**re: Grading and Site Servicing Plan Review**  
**Proposed Self Storage Development**  
**75 Michael Cowpland Drive – Ottawa, Ontario**

**date:** November 24, 2023

**file:** PG3798-MEMO.02 Revision 3

SHEET TITLE
CROSS SECTIONS

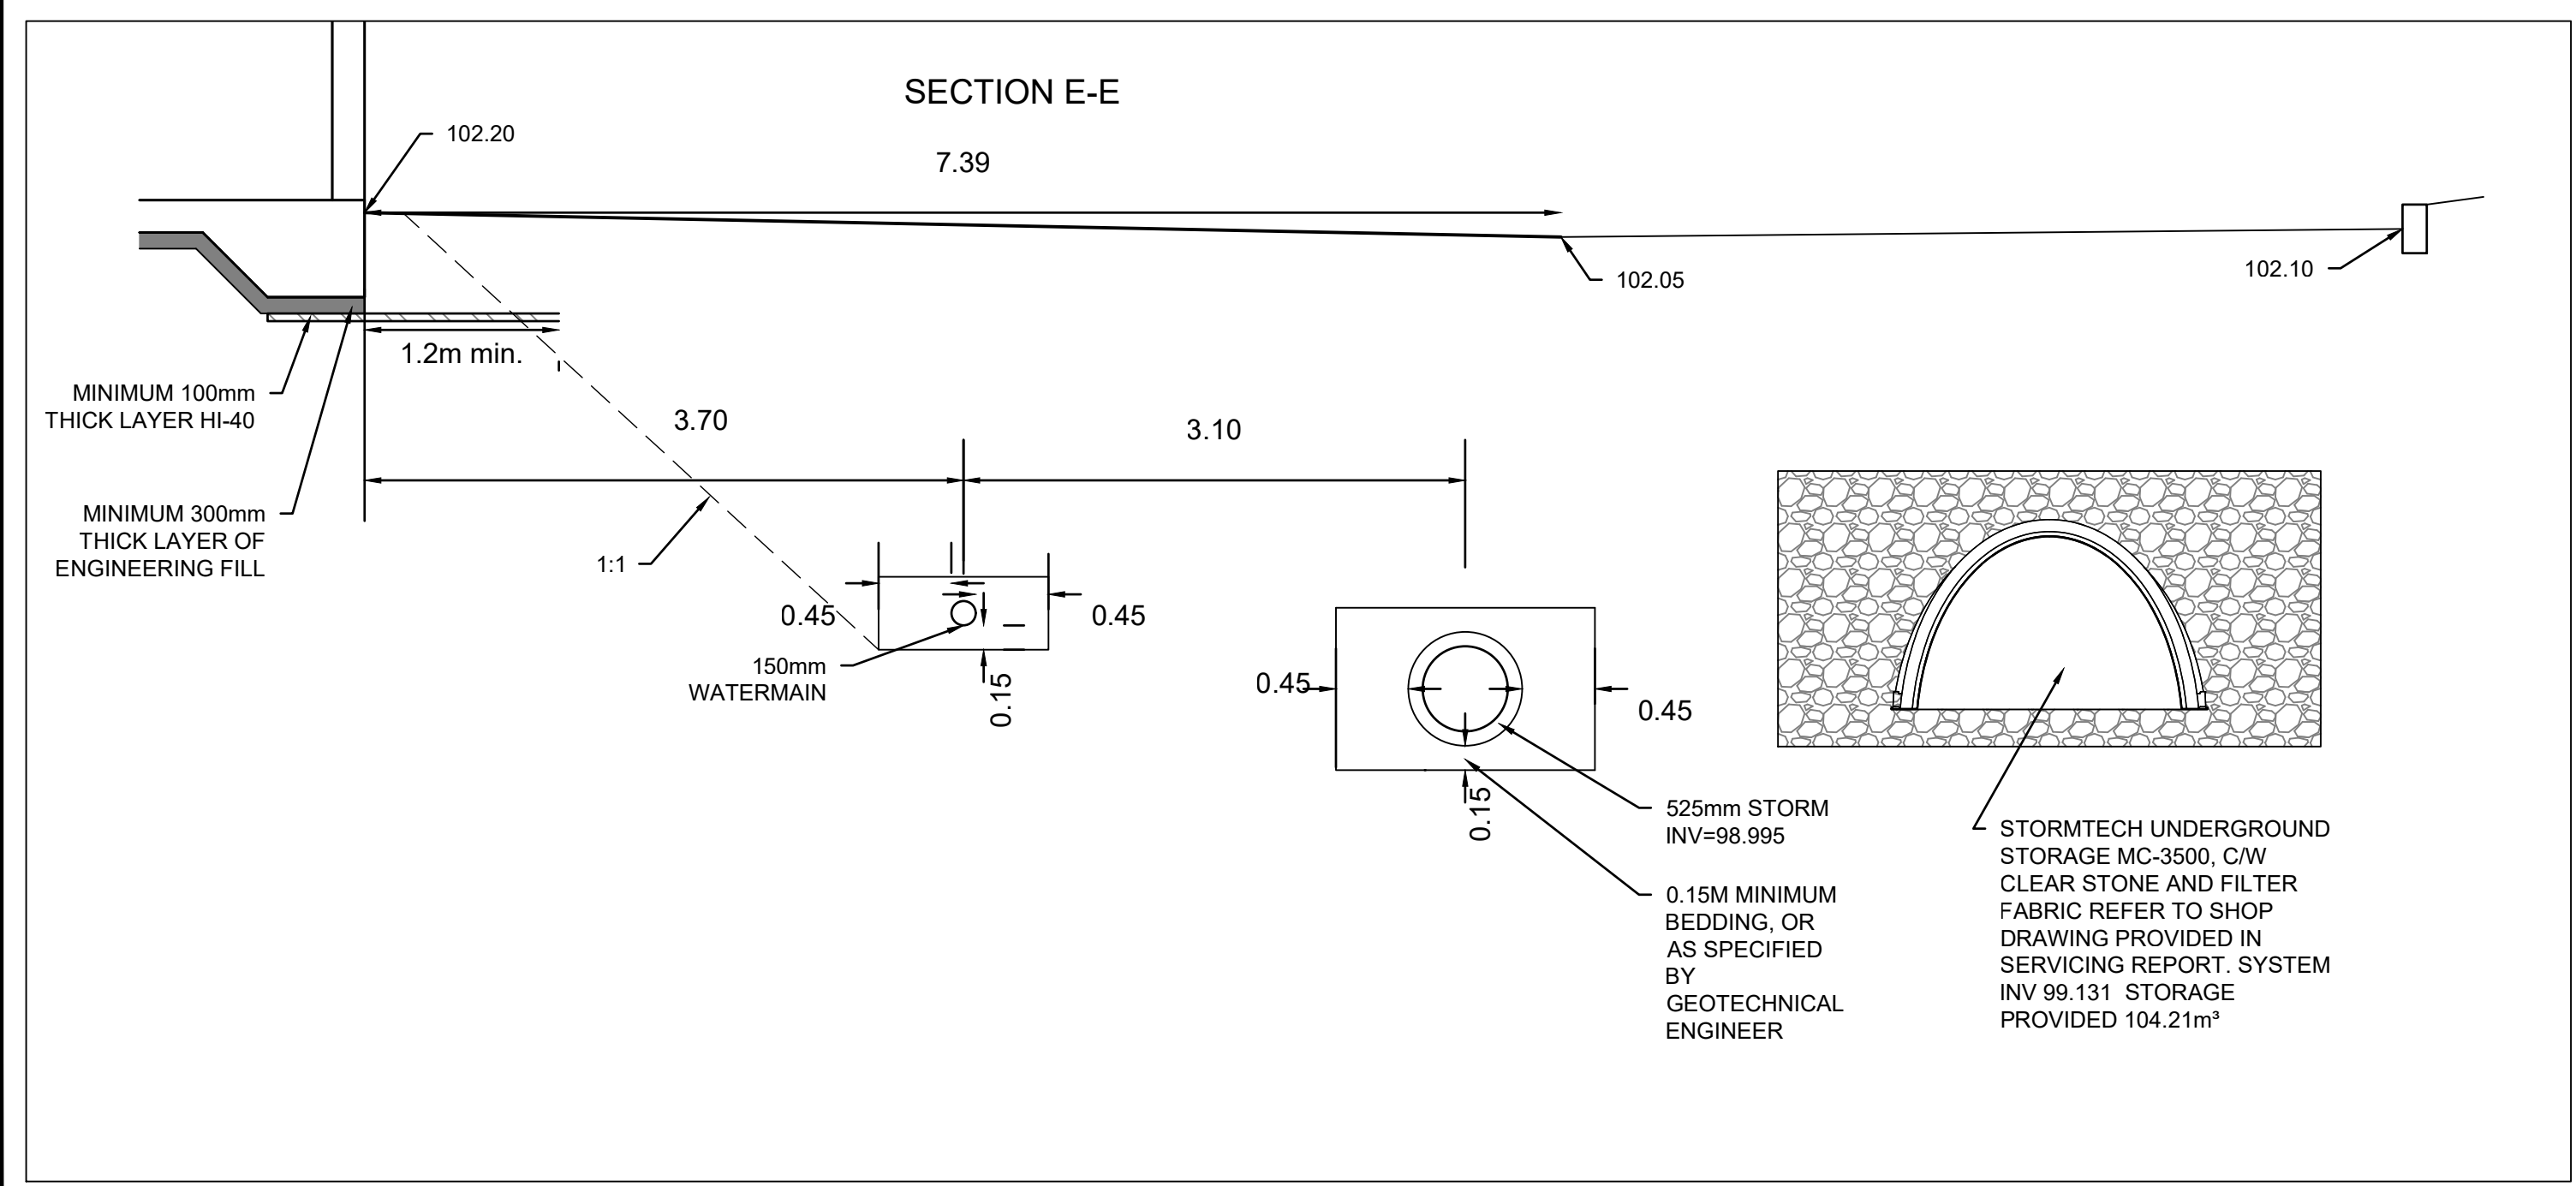
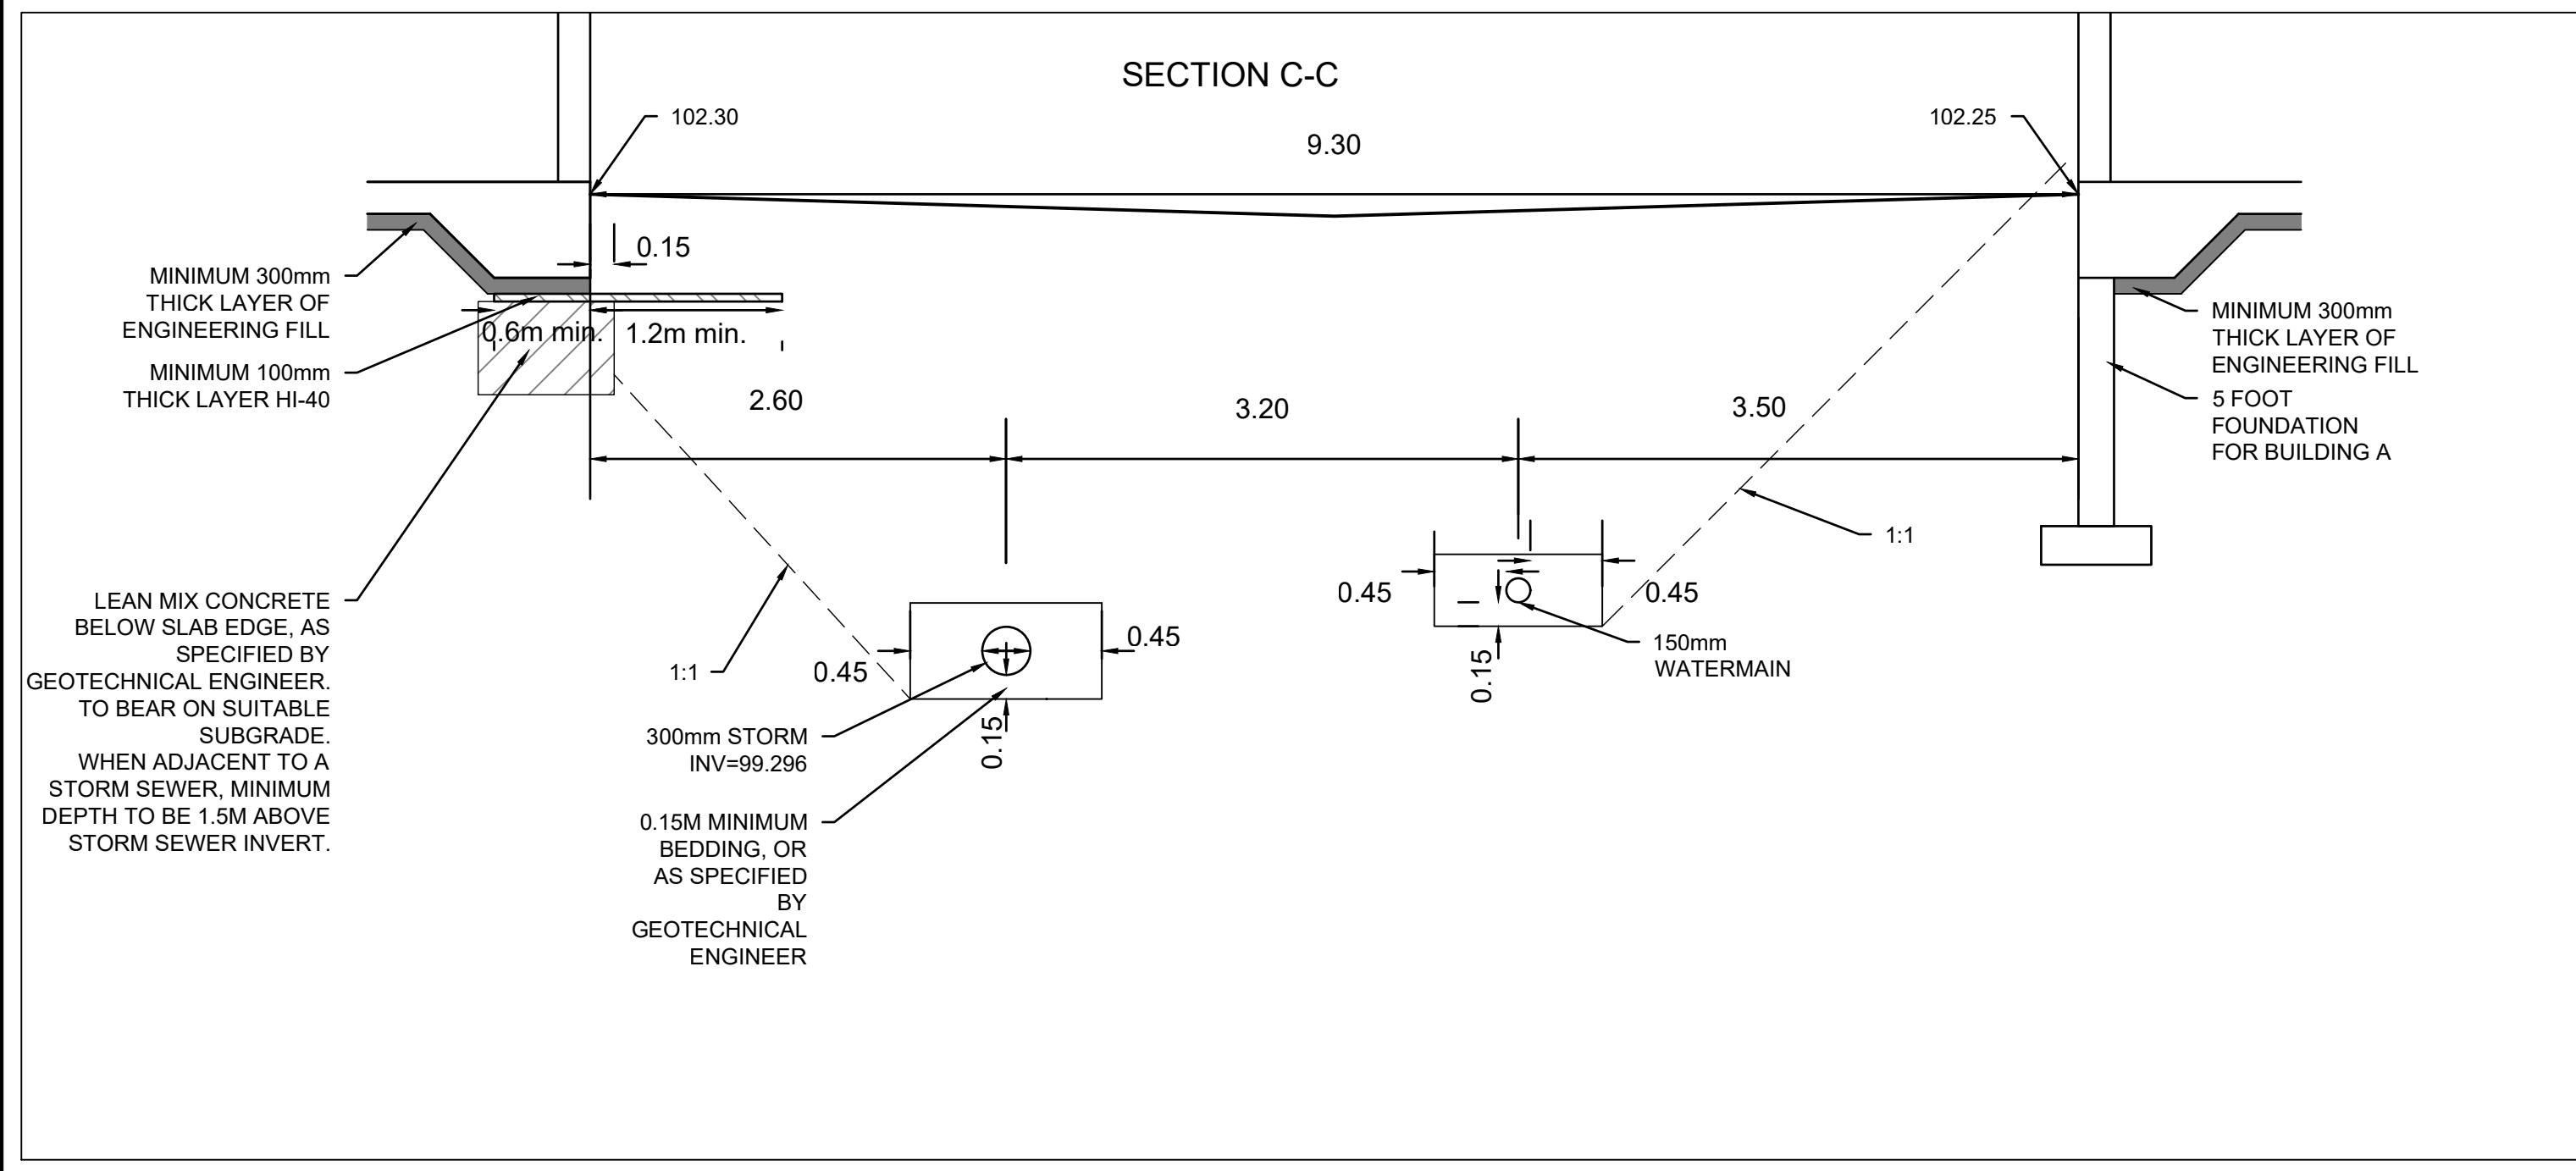
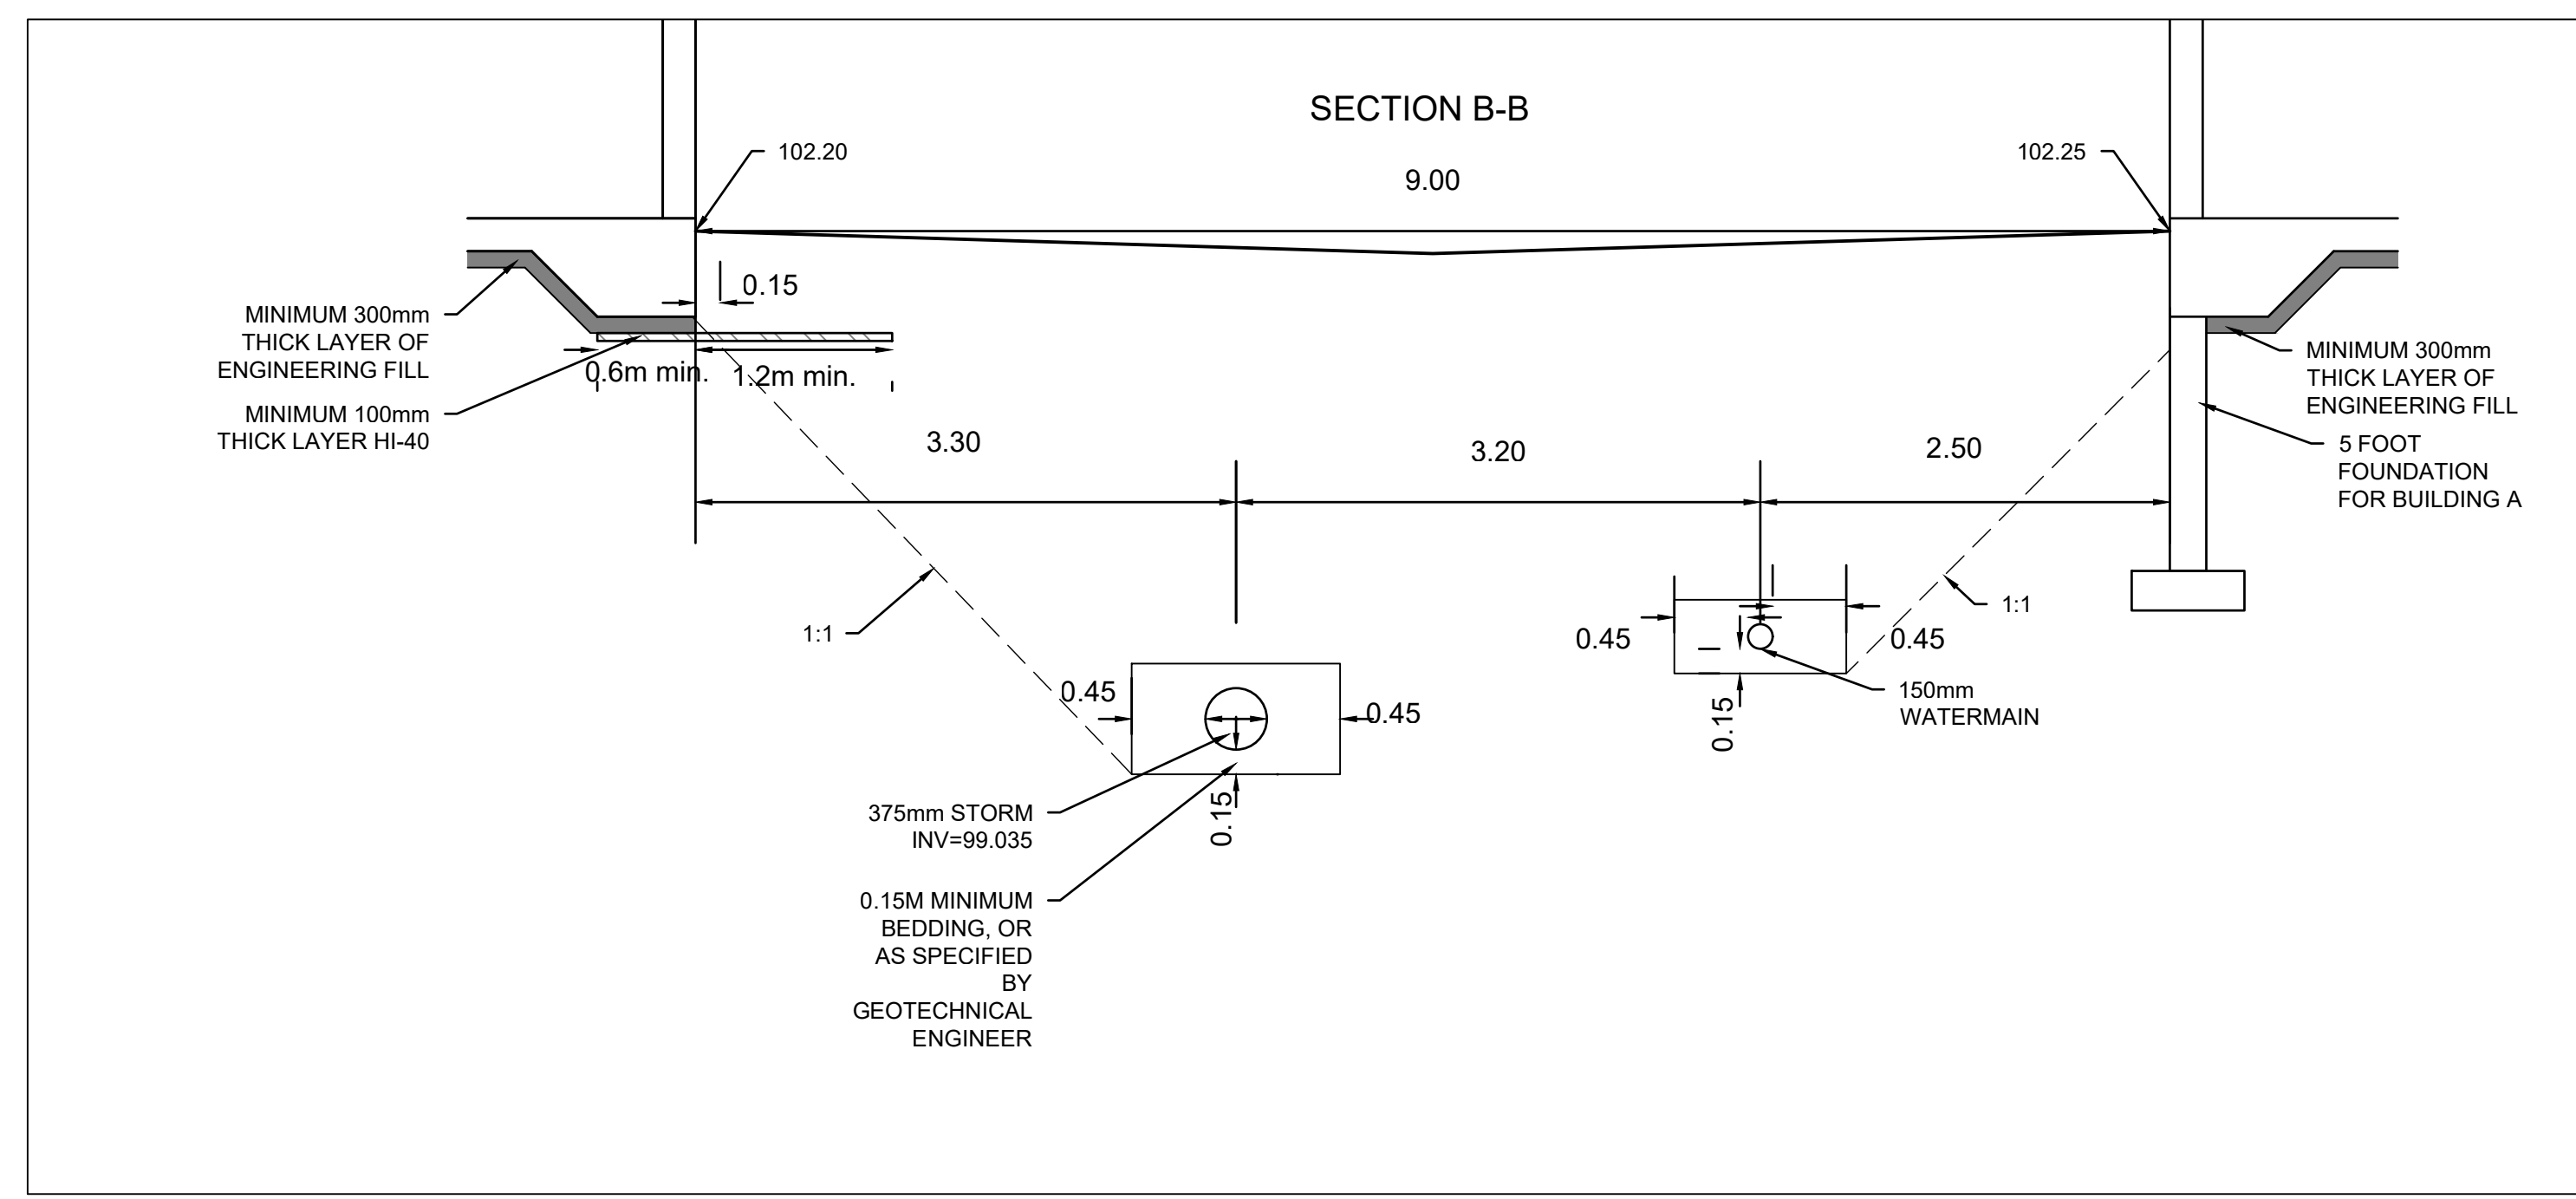
Due to the anticipated depth and proximity of the proposed service pipes to the proposed thickened edge slab footprints, it is expected the lateral support zones for the proposed structures will be negatively impacted by the service installation works. Further, future maintenance that could be considered throughout the proposed service alignments would require trenches that would impact the proposed buildings lateral support zones. Based on this, it is recommended to lower the lateral support zones for thickened edge footings located adjacent to impacting service alignments. This may be accomplished by sub-excavating a near-vertical trench located directly below the overlying footing footprint and in-filled with minimum 17 MPa lean-concrete.

It is recommended the near-vertical trenches extend a minimum of 150 mm horizontally beyond the overlying footing footprint. Based on our review, the lean-concrete trench detail has been incorporated satisfactorily into the above-noted site servicing plans. The recommended perimeter thickened-edge slab foundation insulation detail is depicted below for the proposed storage structures and has been incorporated satisfactorily in the above-noted site servicing plans. The placement of the lean-concrete trench and rigid insulation should be reviewed and approved by Paterson personnel at the time of construction.
